Our ref: DOC20/814200

Your ref: SSD-8184

Subject: EES comments on the Environmental Impact Statement for Fairfield Sustainable Resource Centre expansion (SSD-8184) – corner of Hassall Street and Widemere Road, Wetherill Park

Attachment A**Subject: EES comments on the Environmental Impact Statement for Fairfield Sustainable Resource Centre expansion (SSD-8184) – corner of Hassall Street and Widemere Road, Wetherill Park**

FIGURE 08  
EXISTING 1% AEP HAZARD

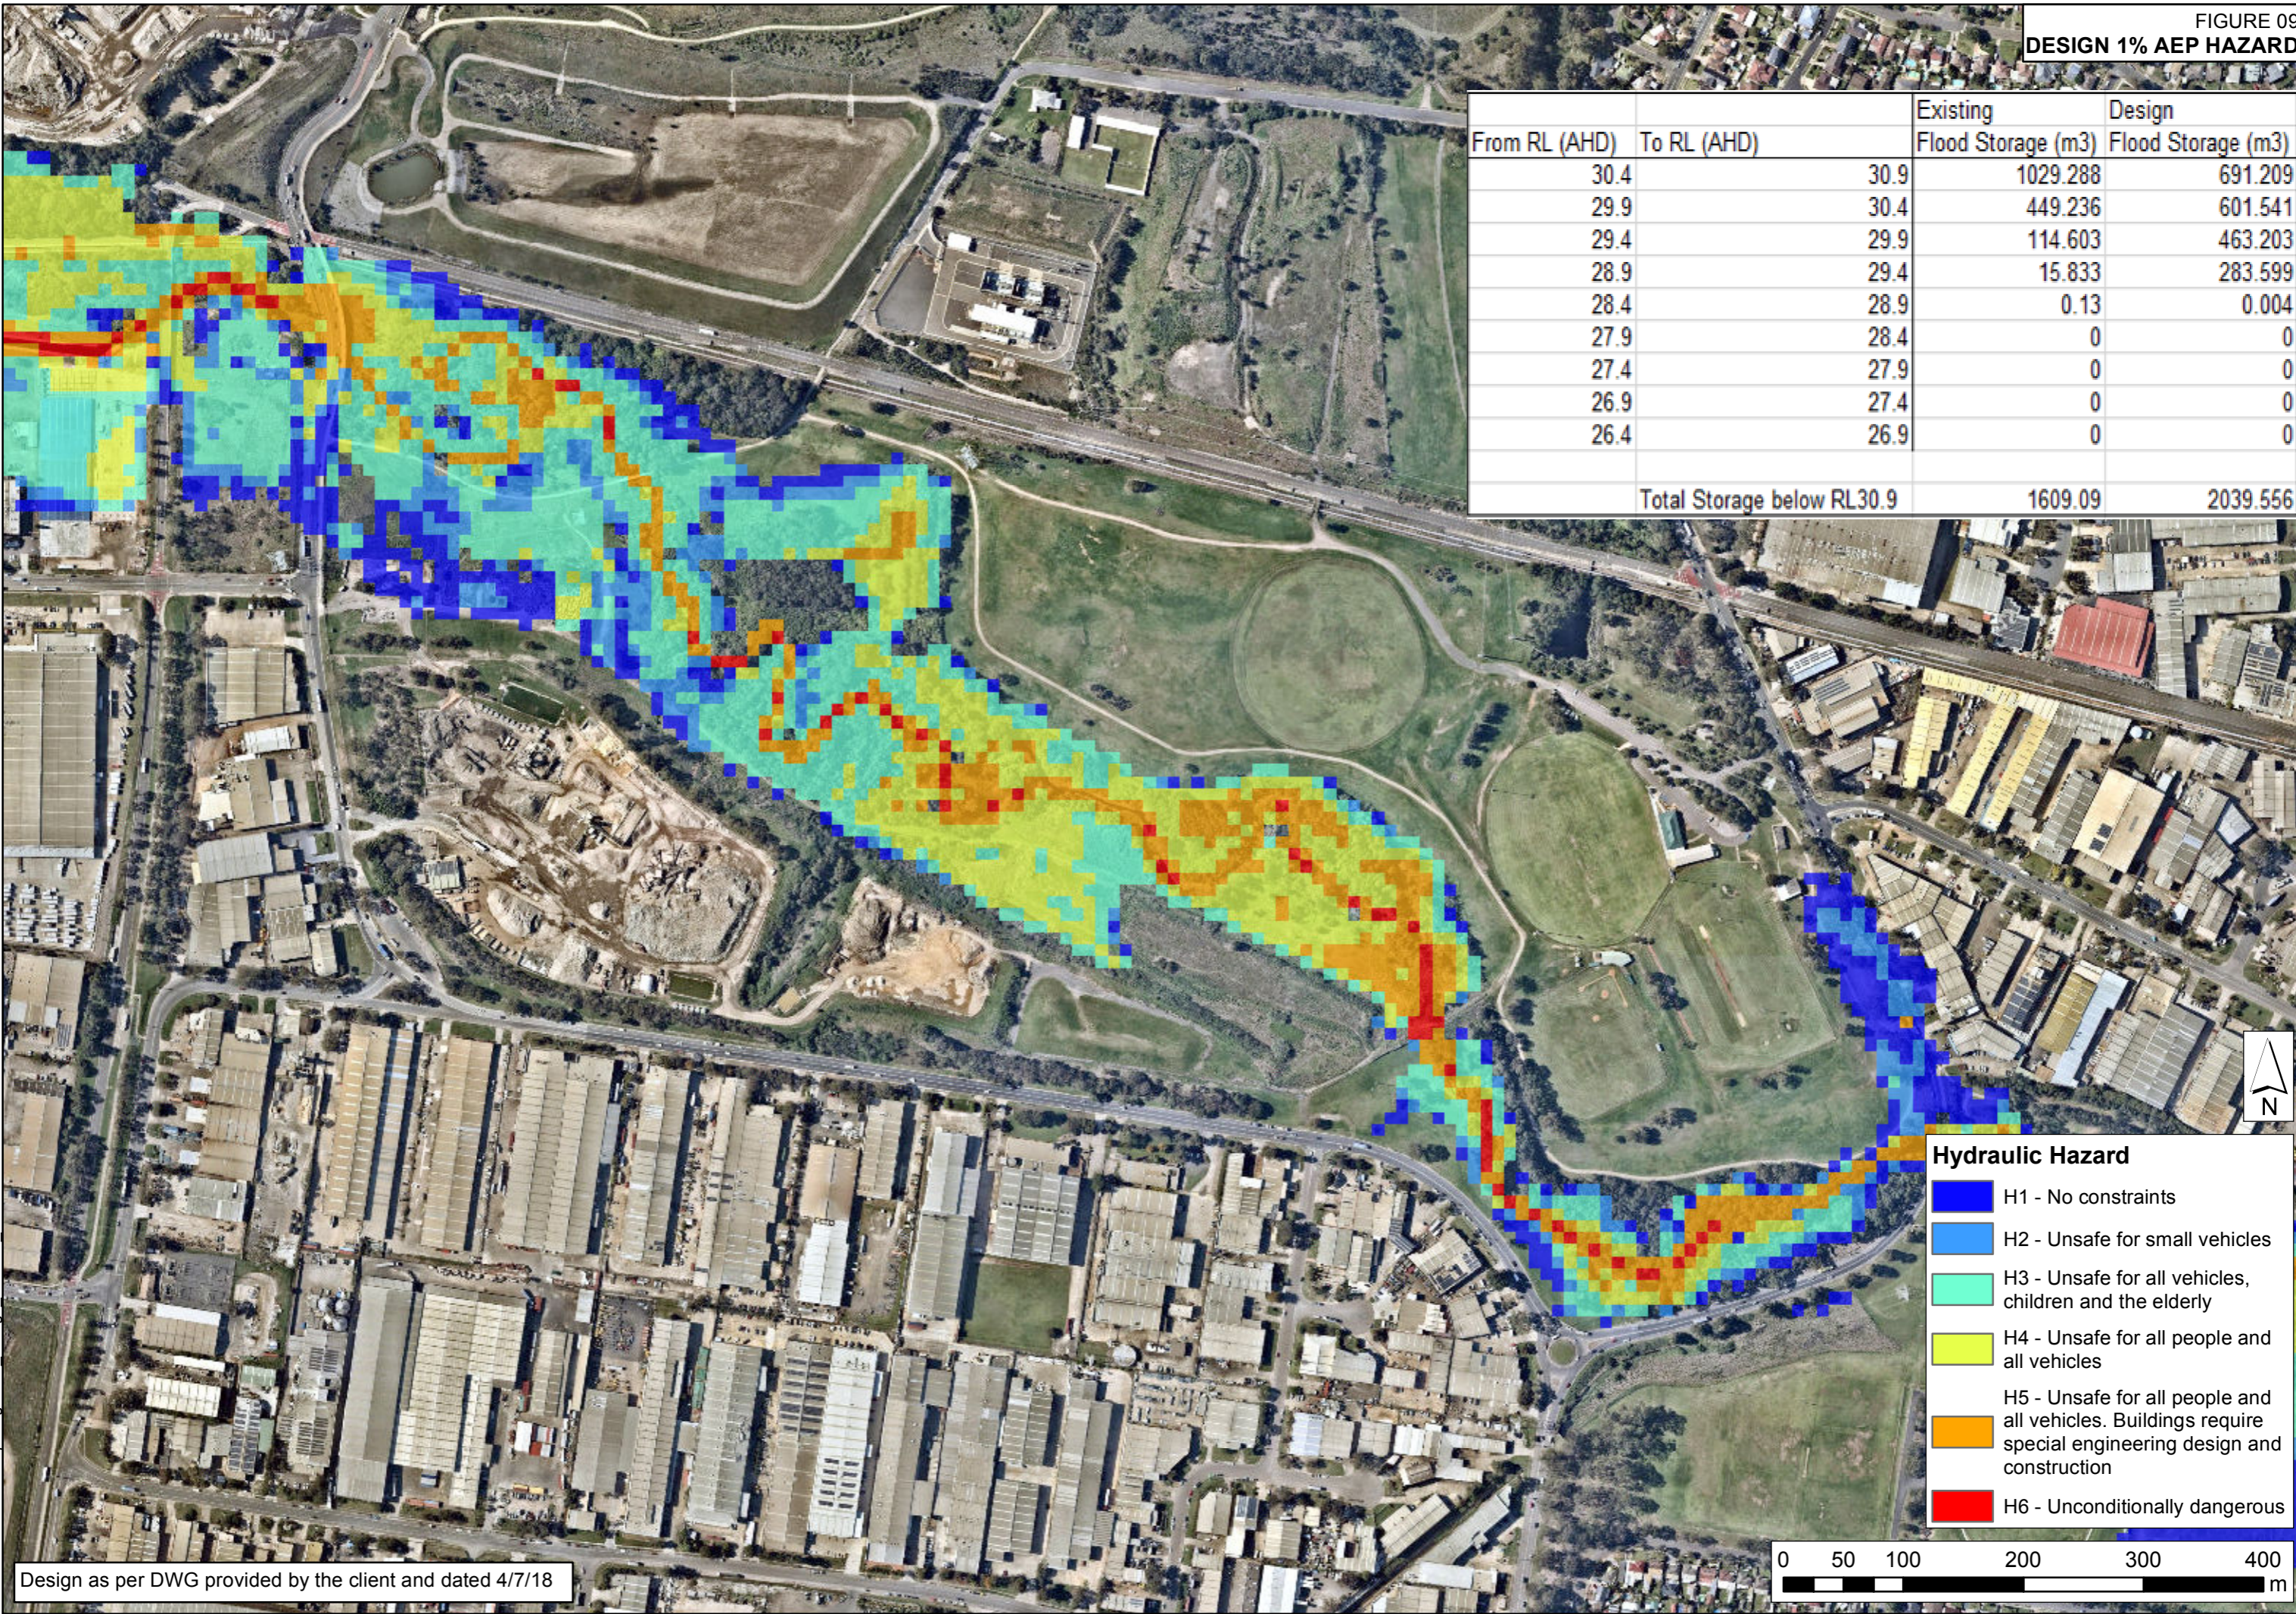
2. The flood assessment should consider the impact from the full range of floods (up to the Probable Maximum Flood) for both mainstream and overland flooding. The latter is addressed in Fairfield Council's Wetherill Park Overland Flood Study. Road inundation problems become important during times of flood and need to be appreciated by the owners and occupiers at the sustainable resource centre (SRC) site.

3. Climate change implications are expected to be minor at this site but nevertheless should be considered in the flood assessment. Sea level rise will impact the downstream end of Prospect Creek at the Hume Highway/Lansvale area. It is possible that the combination of sea level rise and increased rainfall could impact flood levels along the length of Prospect Creek. In 2011, Fairfield Council prepared a report entitled "Georges River and Prospect Creek Climate Change Sensitivity Assessment". For overland flooding, the assessment should consider a 10%, 20% and 30% rainfall increase. For mainstream flooding the 0.5% and 0.2% AEP events can be adopted as a proxy. The proposed development particularly the flood mitigation facilities should be designed to accommodate the potential climate change impacts. The 0.5m freeboard should not be eroded to account for climate change impacts.

5. The EIS should incorporate appropriate management measures regarding a Flood Emergency Plan, a binding requirement ensuring the proposed 1500m³ flood storage area is used exclusively for flood storage and the limiting of activities or works within the lower parts of the Prospect Creek floodplain, identified as a High Flood Risk Precinct, and in accordance with Fairfield Council's Development Control Plan for flooding.

## Landscape Development Application

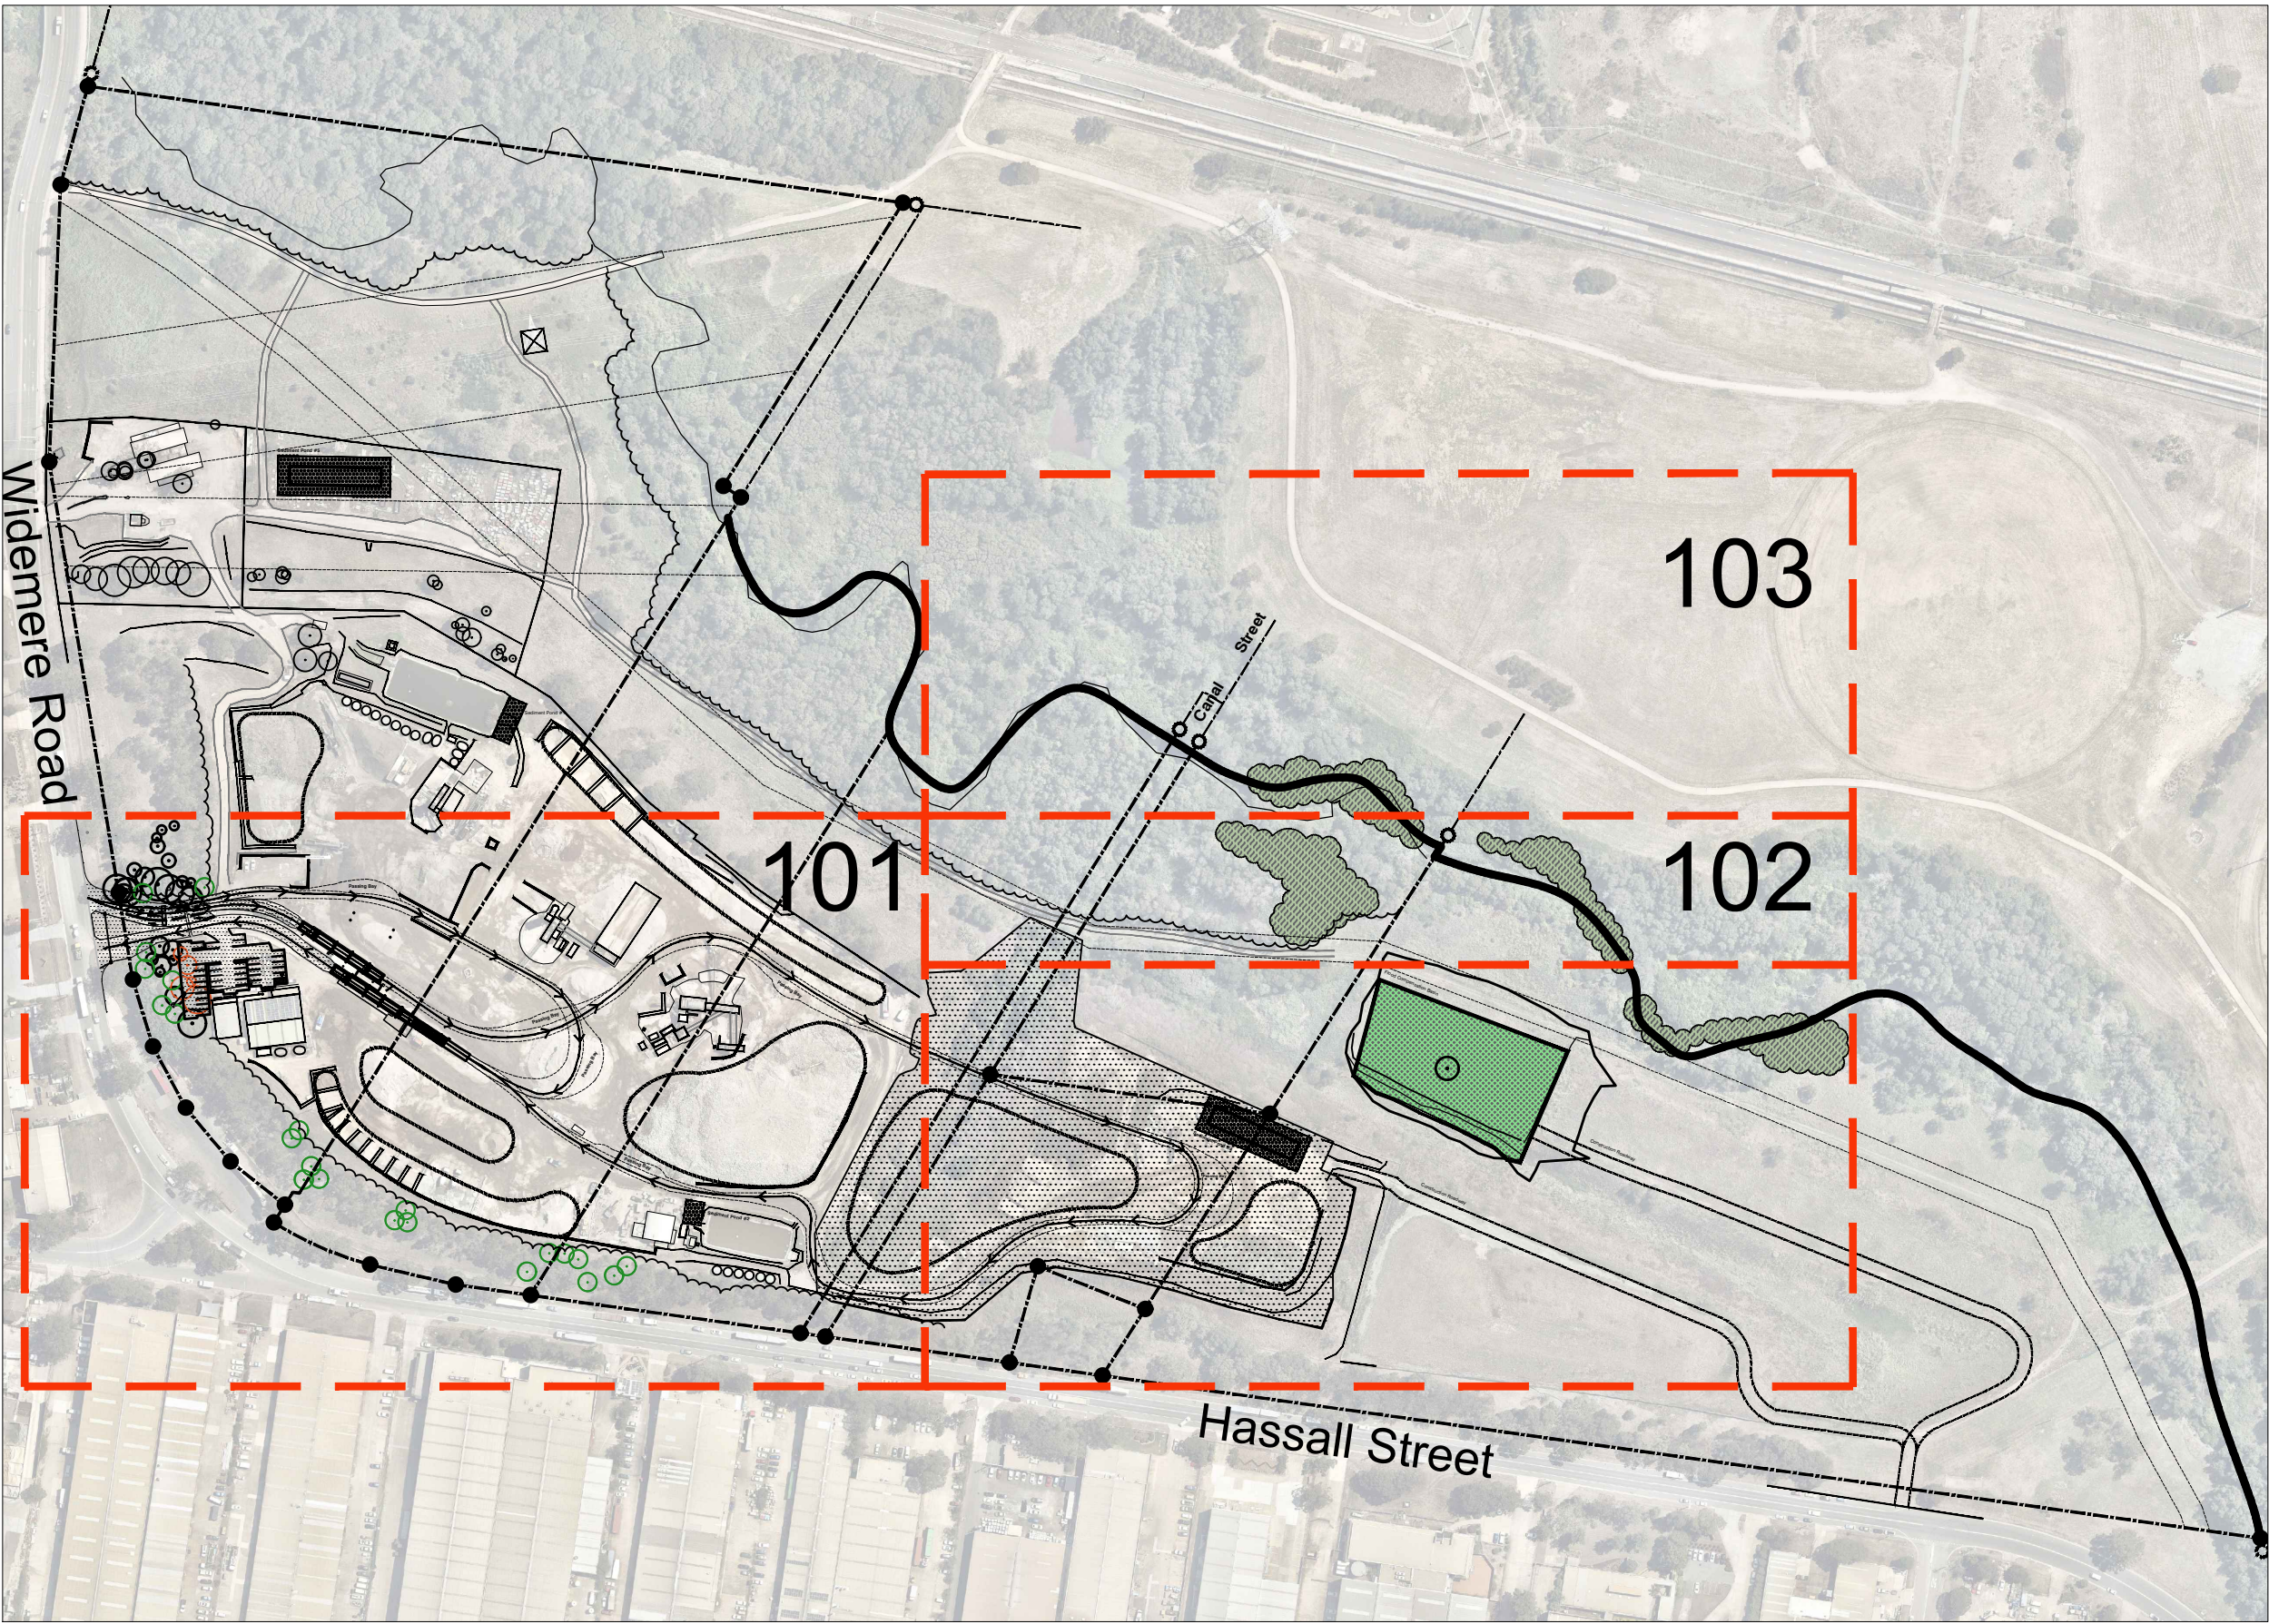
The RTS should confirm if the replacement trees are proposed to be planted along Prospect Creek as Table 15 in the BAR refers to revegetation/replanting along Prospect Creek and revegetation/planting as per Landscape Plan (see pages 39 and 40). The EIS notes the existing riparian corridor will be enhanced by the provision of additional plantings (section 5.3.3, page 24) and the Landscape Plans show indicative supplementary revegetation along Prospect Creek.

EES supports additional planting along the Prospect Creek riparian corridor, particularly as the BAR states "riparian vegetation along Prospect Creek has been identified as a regional corridor (OEH 2015)". The Landscape Plans show indicative supplementary revegetation along Prospect Creek, but the plan notes the "planting locations and extents are subject to detailed review of existing vegetation". It is unclear when this detailed review and planting is to occur and details are required. A diversity of local native provenance species should be used from PCT 835.
